15 March 2024

**SECTION 73 APPLICATION TO VARY CONDITION 1 RELATED TO APPROVED DRAWINGS TO PLANNING CONSENT 23/00863/FUL.
AT BOB'S FARM, VYNE ROAD, SHERBORNE ST JOHN, HAMPSHIRE, RG24 9HX.
FOR THE ERECTION OF 9 DWELLINGS AND ASSOCIATED LANDSCAPING, ACCESS AND CAR PARKING FOLLOWING THE DEMOLITION OF EXISTING AGRICULTURAL AND B8, STORAGE AND DISTRIBUTION USE BUILDINGS AND HARDSTANDING.**

JOB NO.: 8160 DRAWING NO.: D08 REV: B

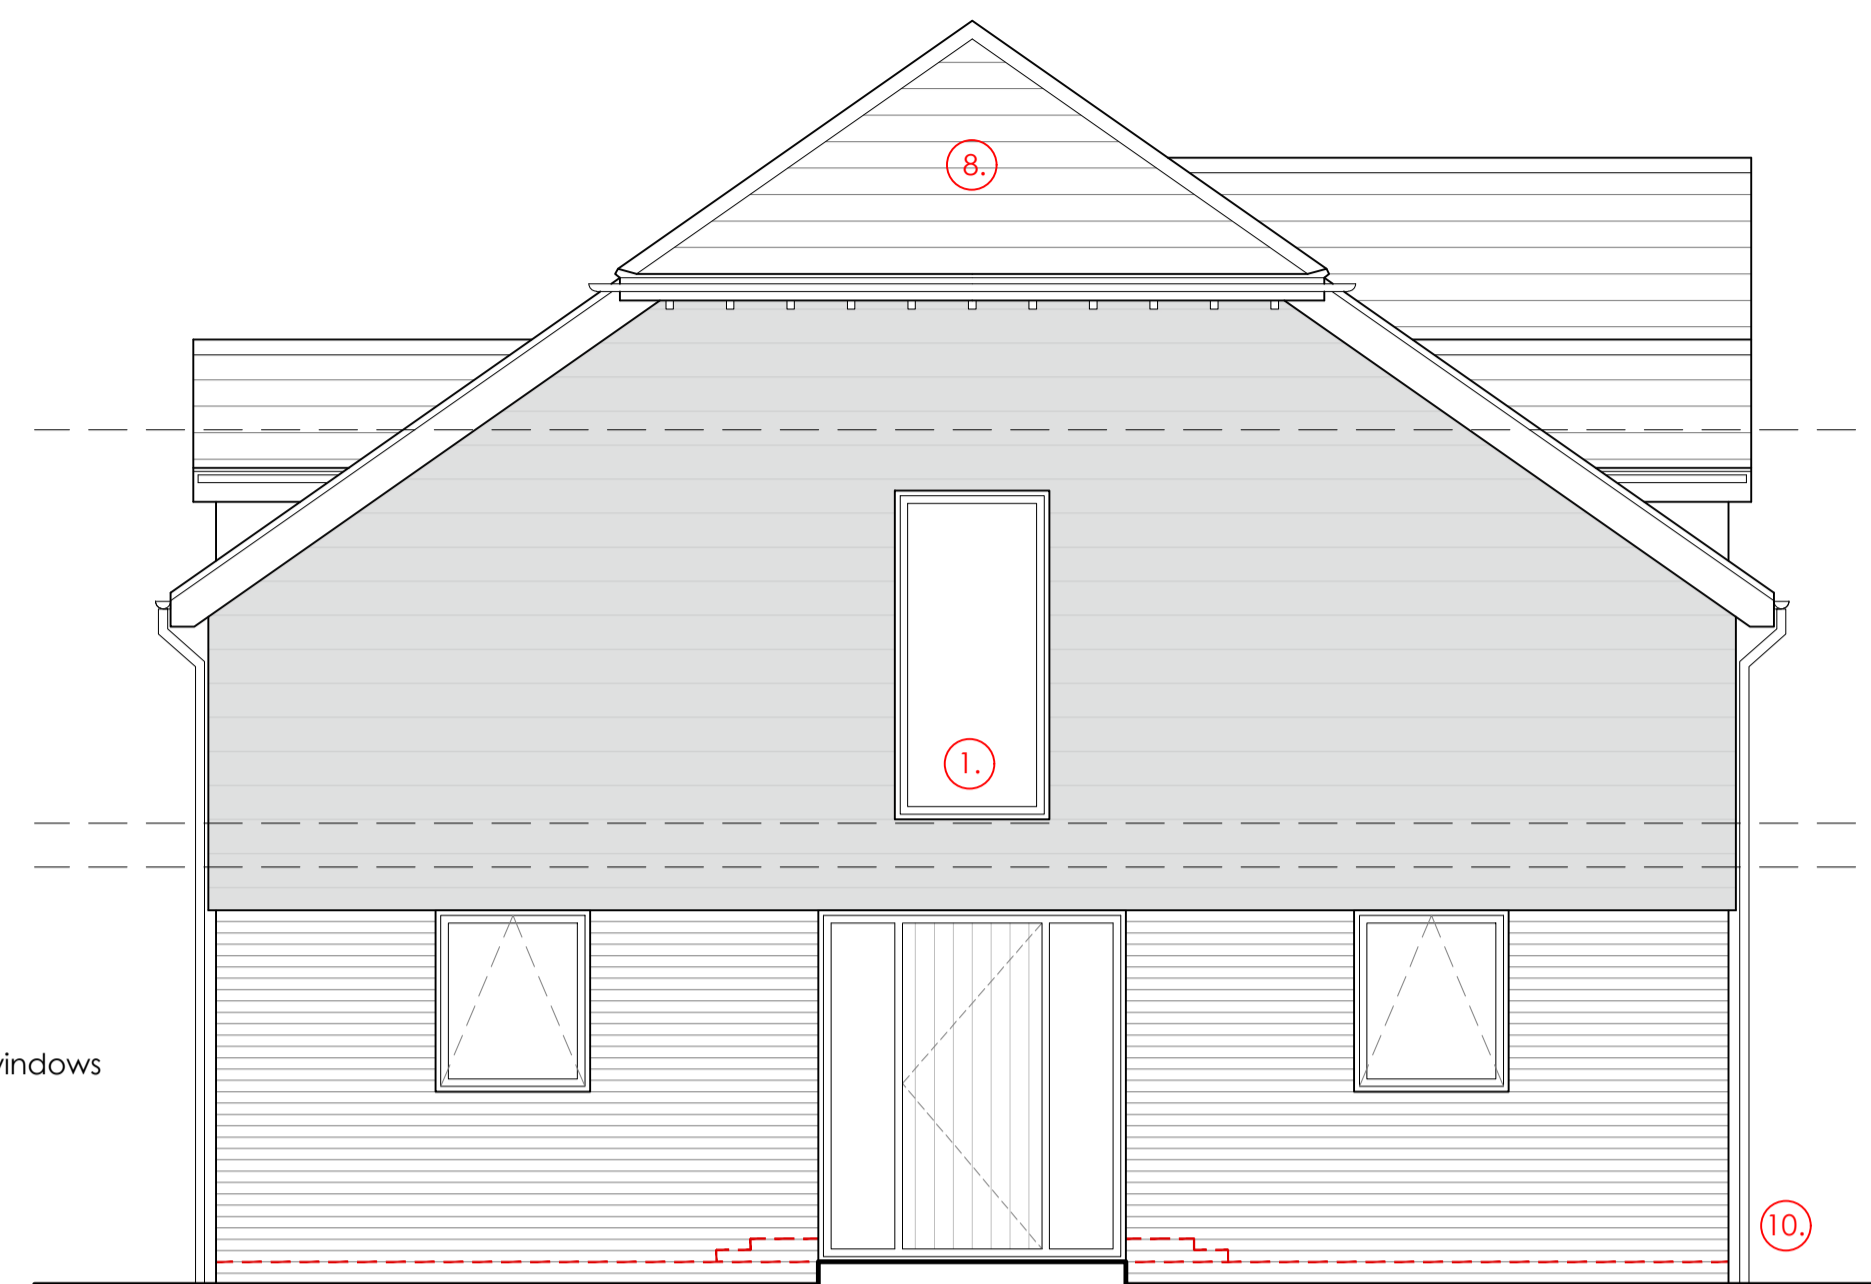
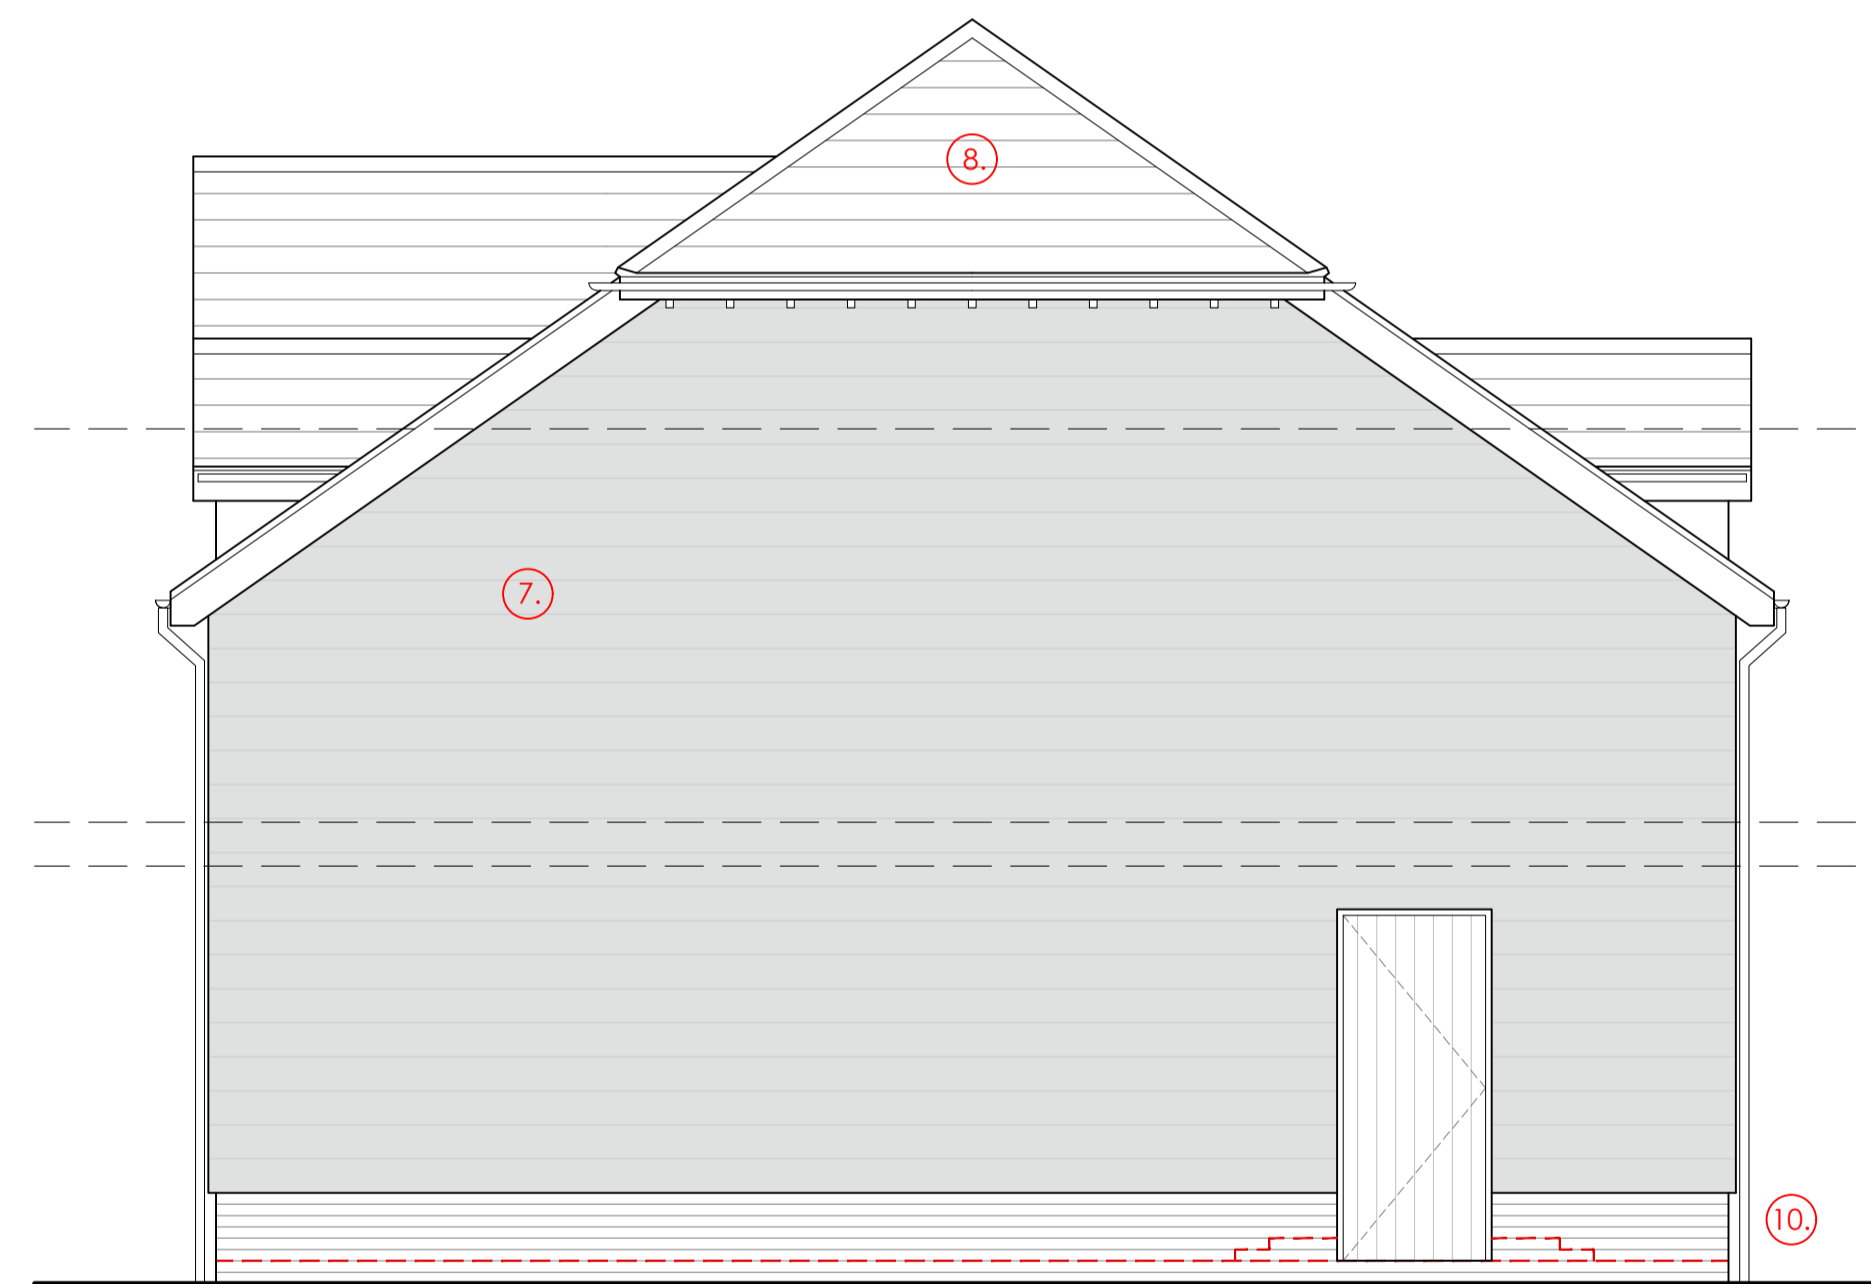
- Plot 1 – amend roof type to omit flat roof; fenestration changes; amend chimney position and reduce height; and change clay tiles with slate.
- Plots 2 & 3 – fenestration changes including additional window and sunpipe; remove flue; and change slate tile to clay tiles.

JOB NO.	DRAWING NO.	REV
8160	D11	C

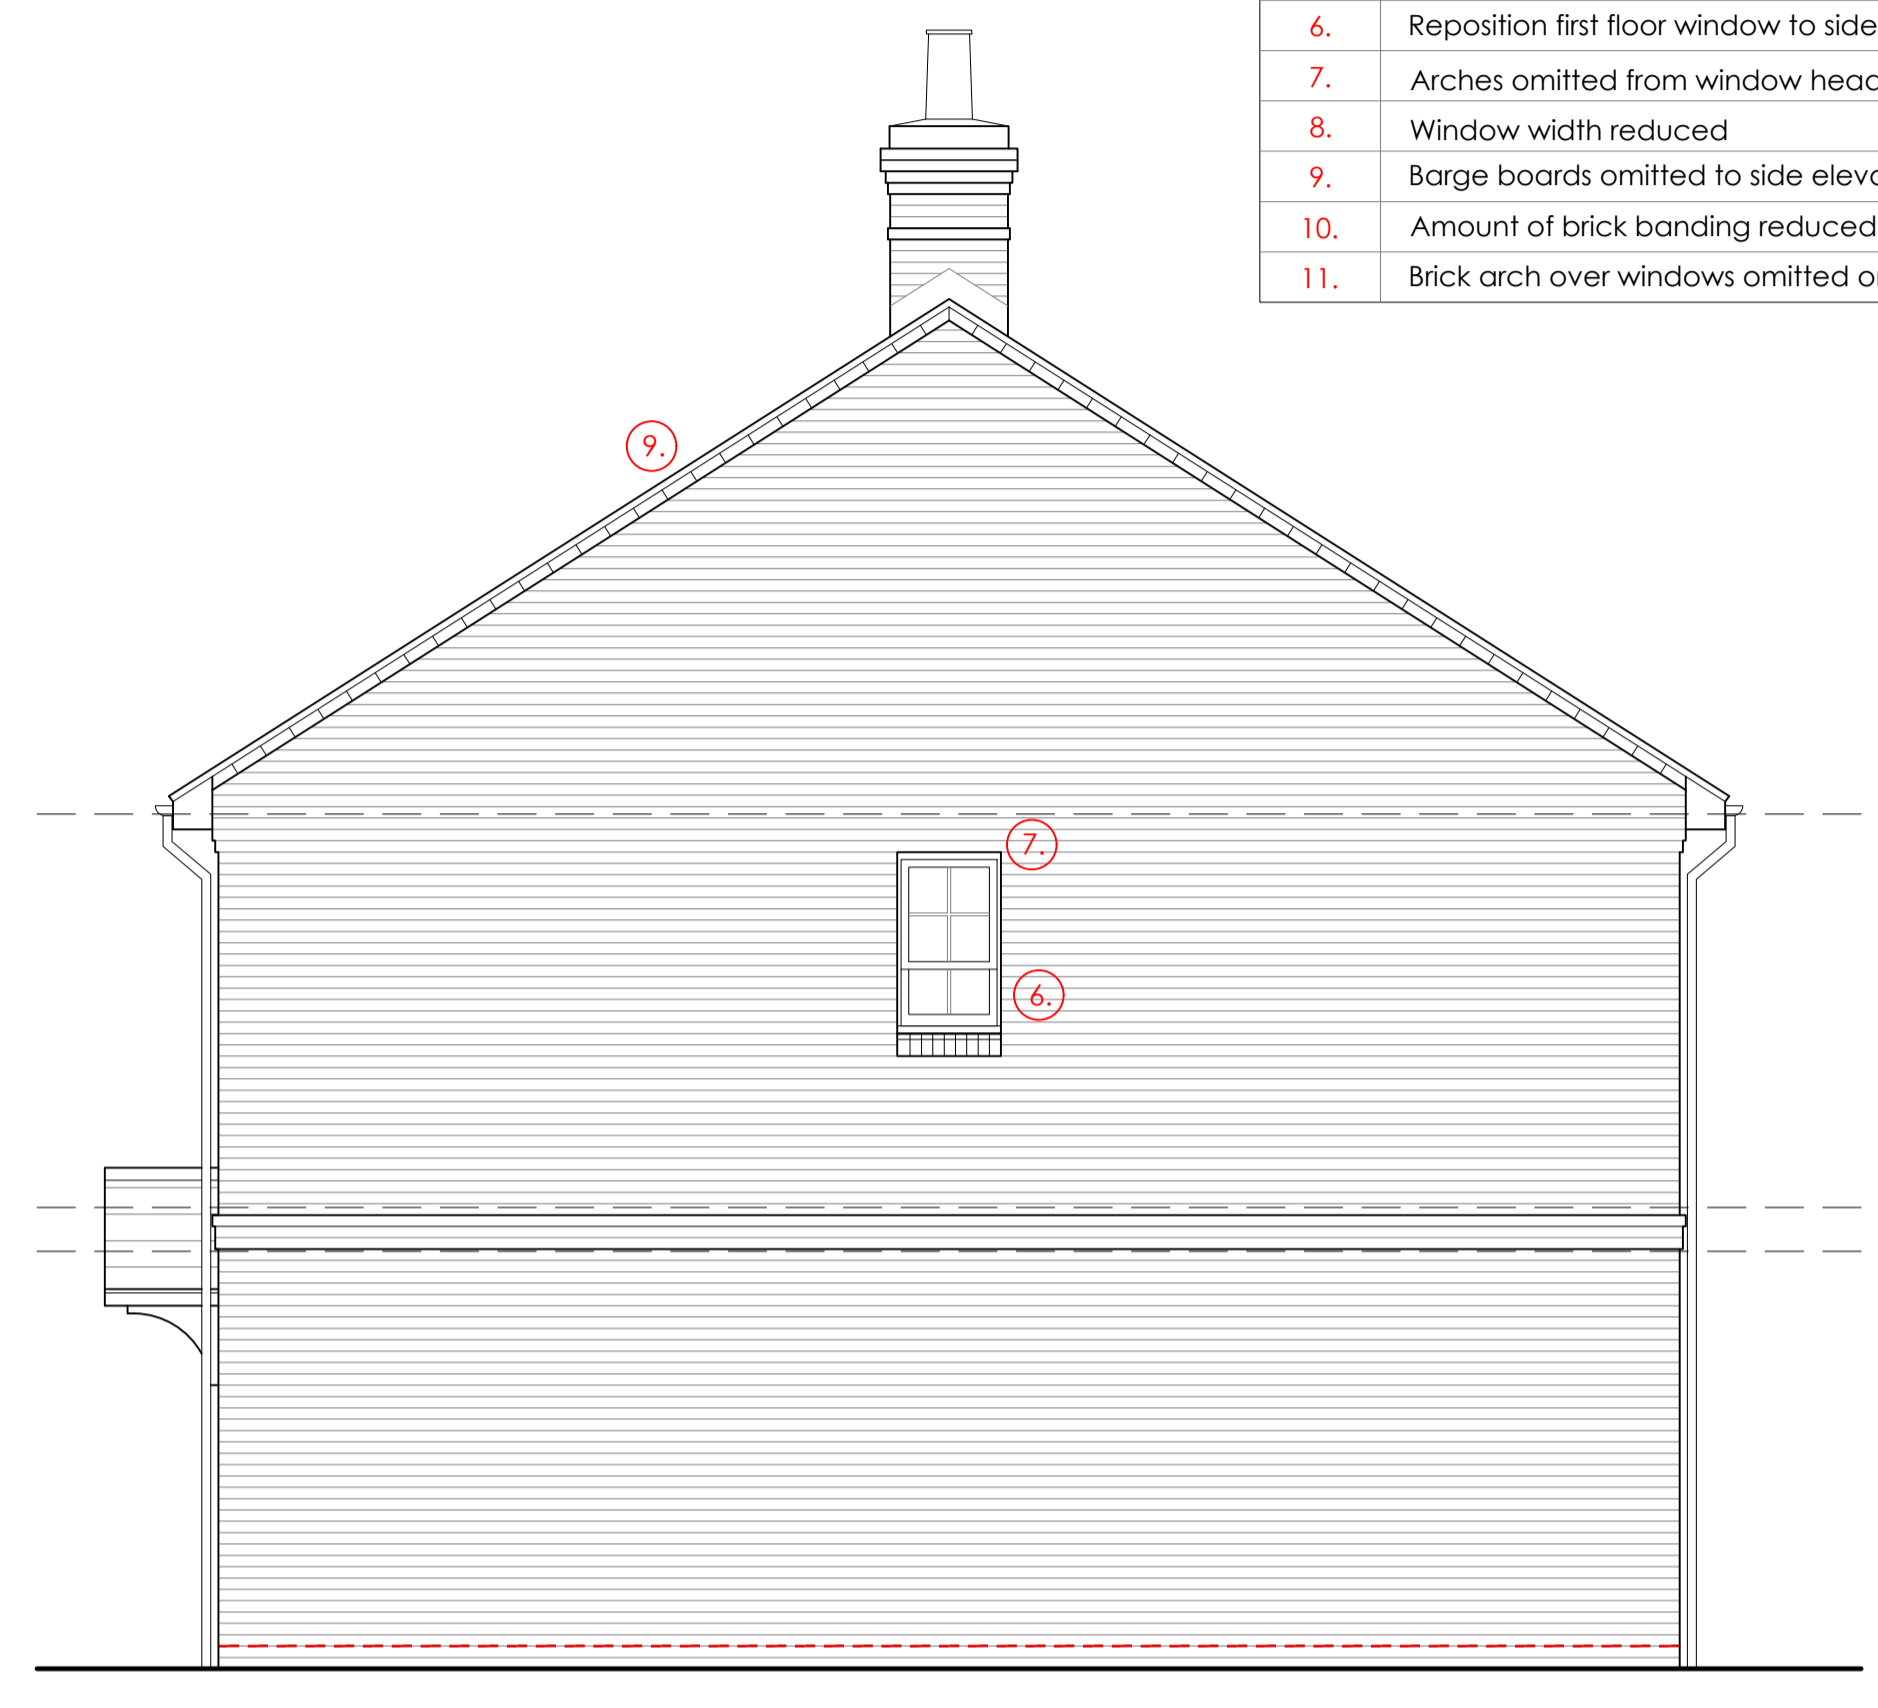
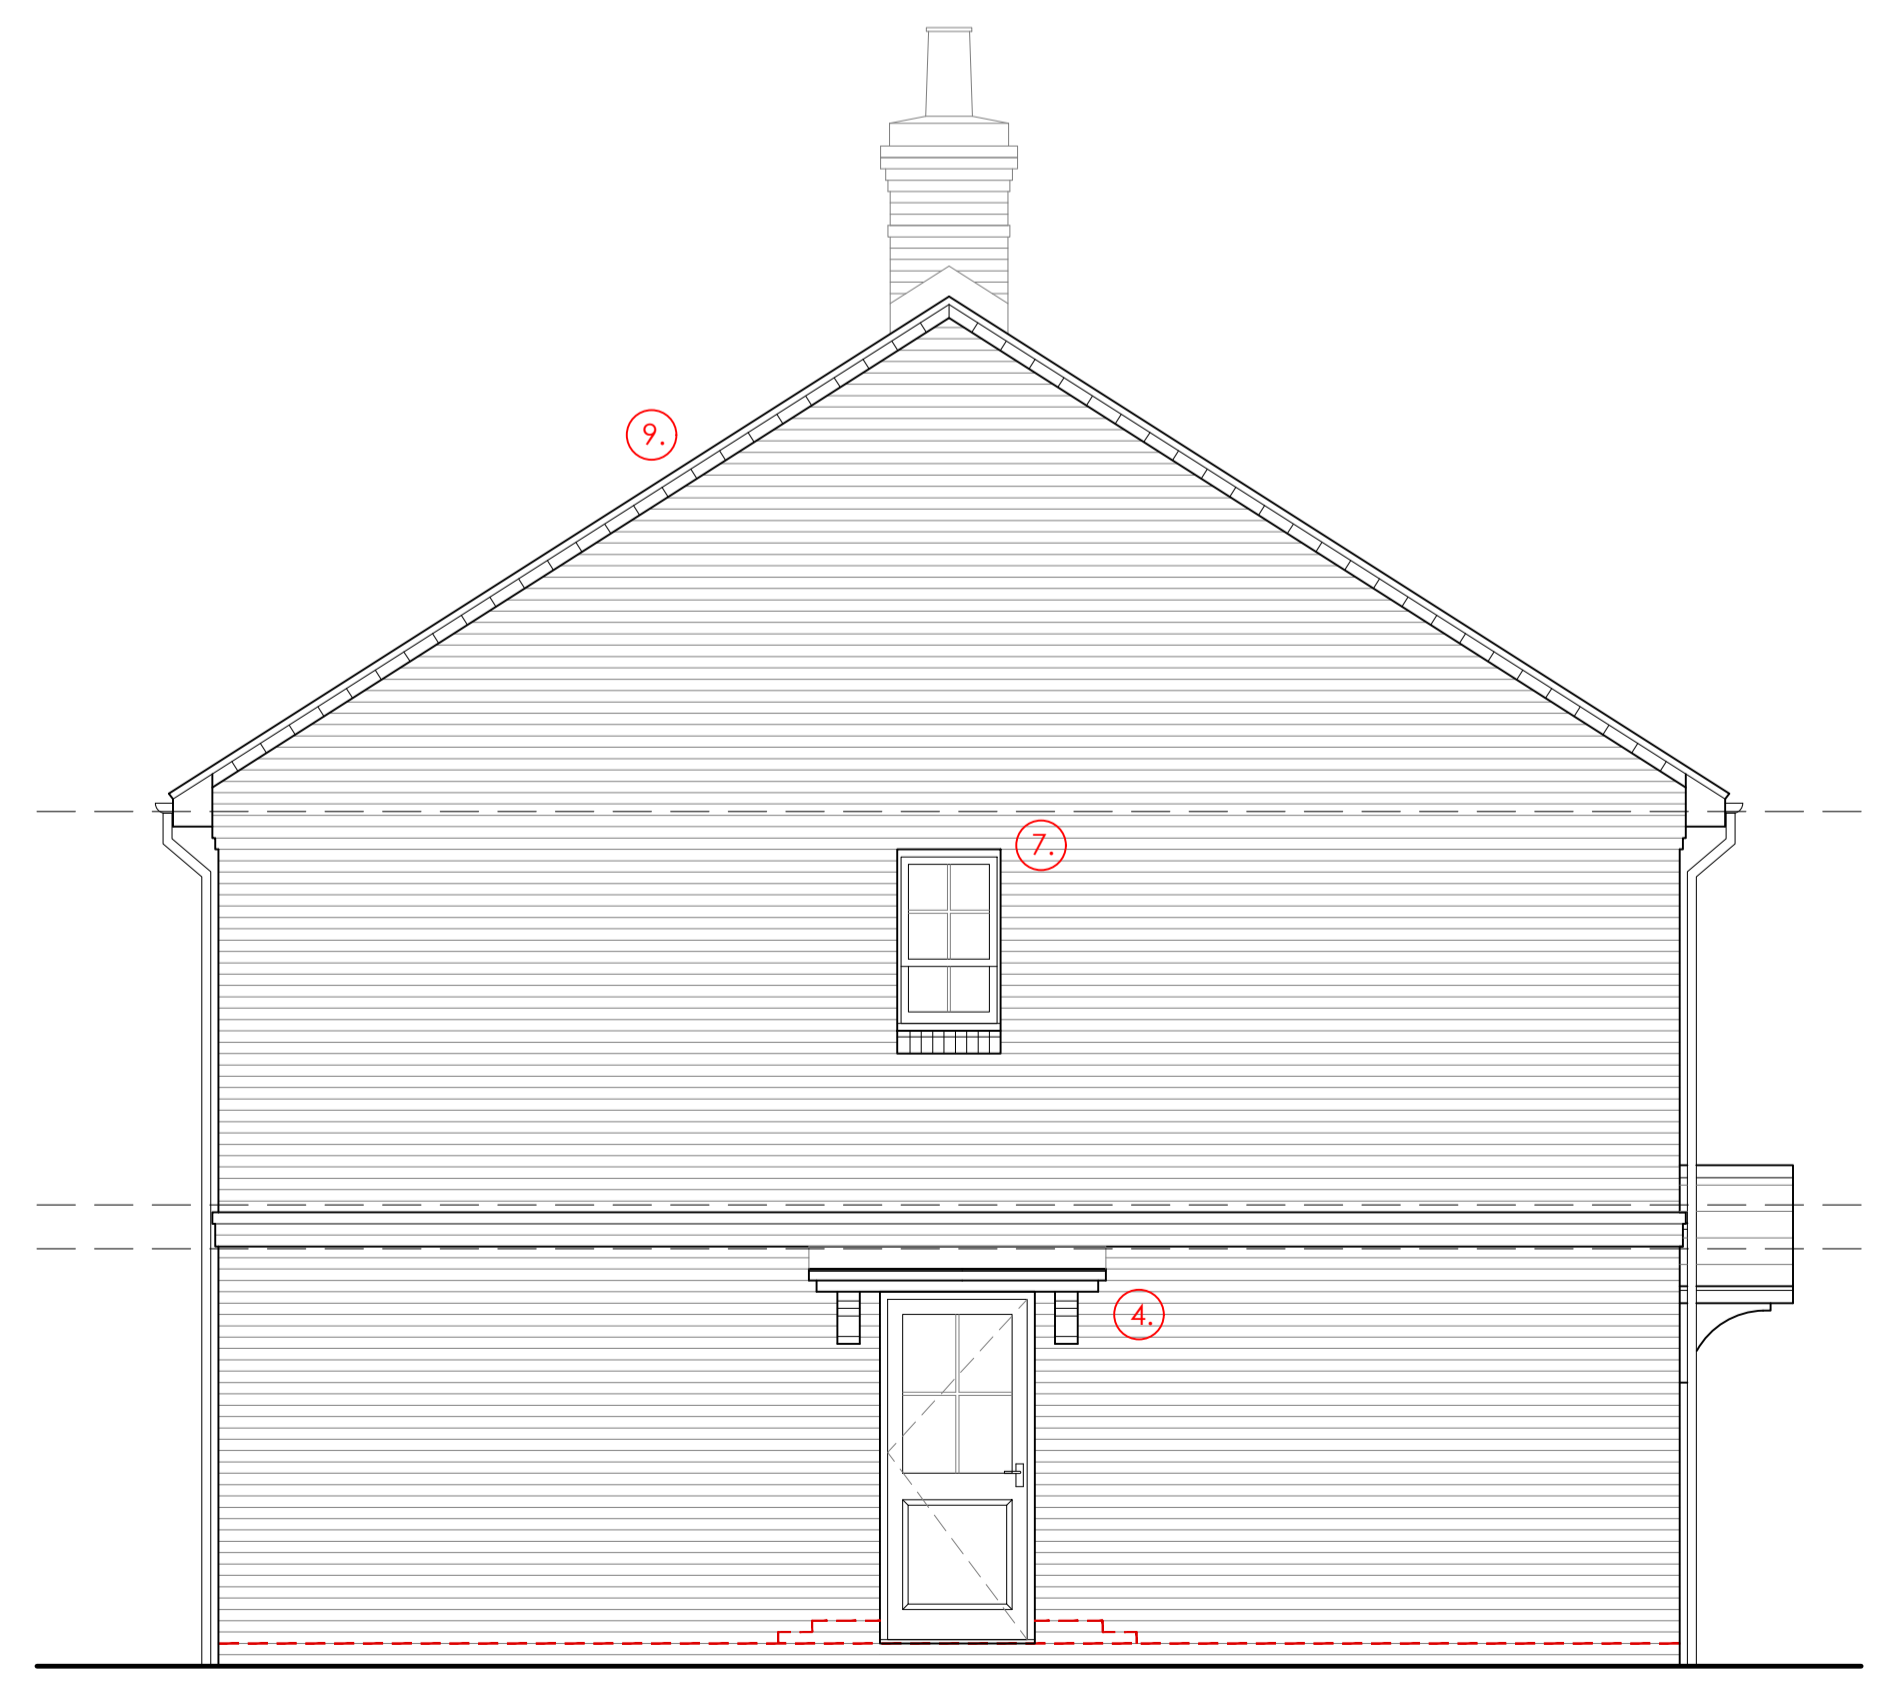
- Plot 4 – fenestration changes; and remove one chimney.
- Plot 5 – fenestration changes including removal of windows and rooflights, and add sunpipe; and remove flue.
